Your Ref: 2025/0850

Our Ref: B/01504

**Land adjacent 2 Cemetery Road, Bolton Upon Dearne, Rotherham, S63 8LS - (BARNs) -
Erection of 3no dwellings (Outline with all matters reserved)**

Plan 2 Tree Constraints Plan showing the proposed layout

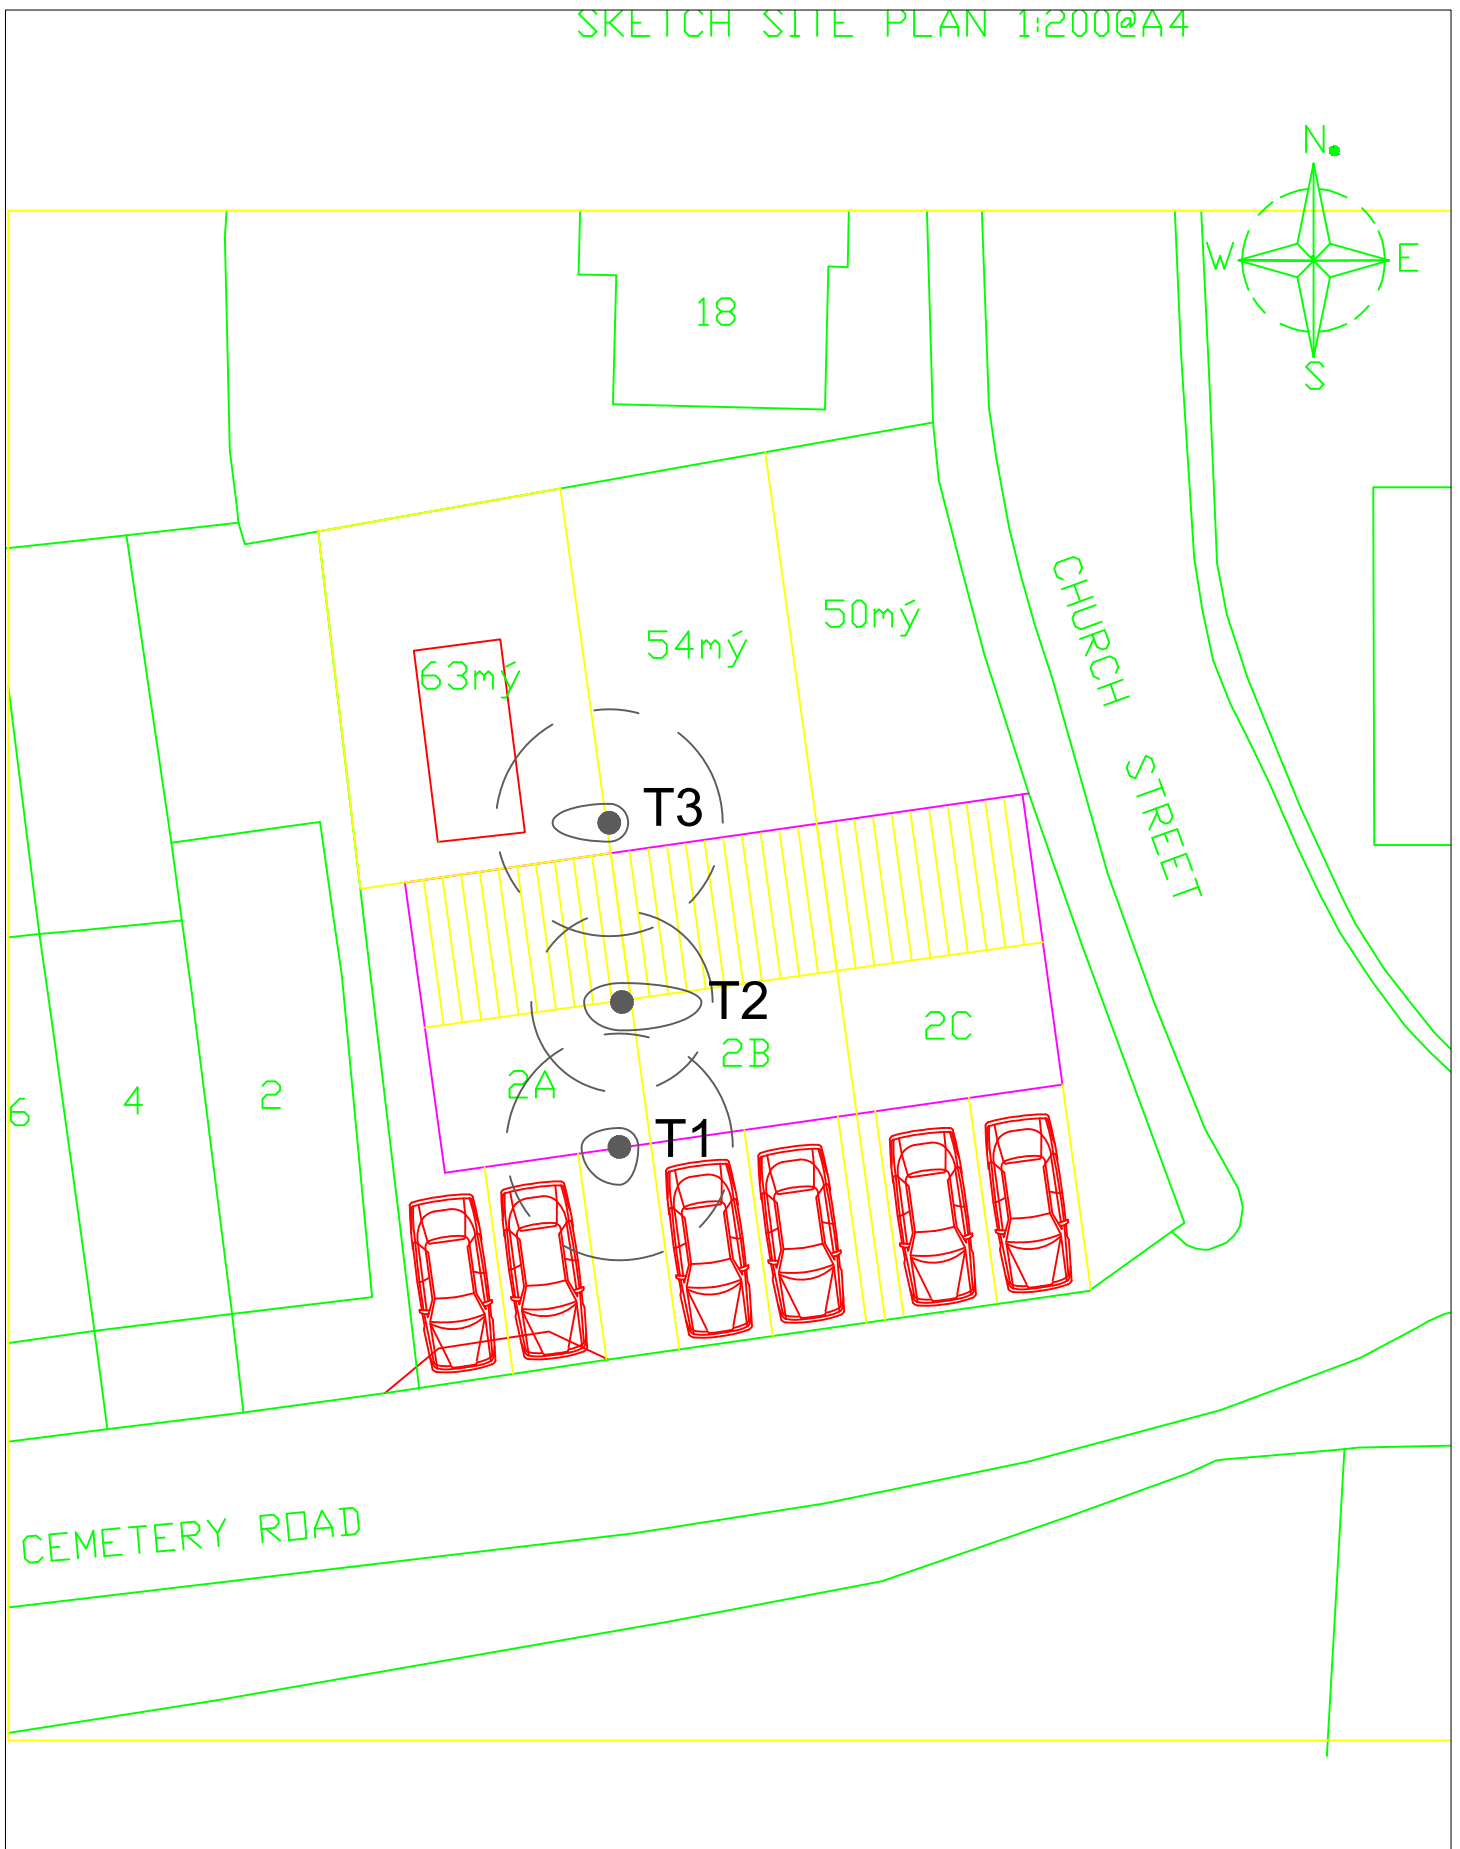
- 1.) Yorkshire Water has no objection in principle to the drainage details submitted on drawing 'Sketch Site Plan' as prepared by Peter Thompson, namely
 - a.) The proposed separate systems of drainage on site
 - b.) The proposed amount of domestic foul water to be discharged to the public combined water sewer
 - c.) The proposed amount of curtilage surface water to be discharged - to soakaway - please note however that the position of the soakaway will likely not be accepted by building control.

It is noted from the submitted planning application that surface water is proposed to be drained to soakaway – While Yorkshire Water endorses this means of surface water disposal, soakaways may not be situated within 5 metres of a building or curtilage boundary. The developer is encouraged to consult with building control for a revised position for the soakaway
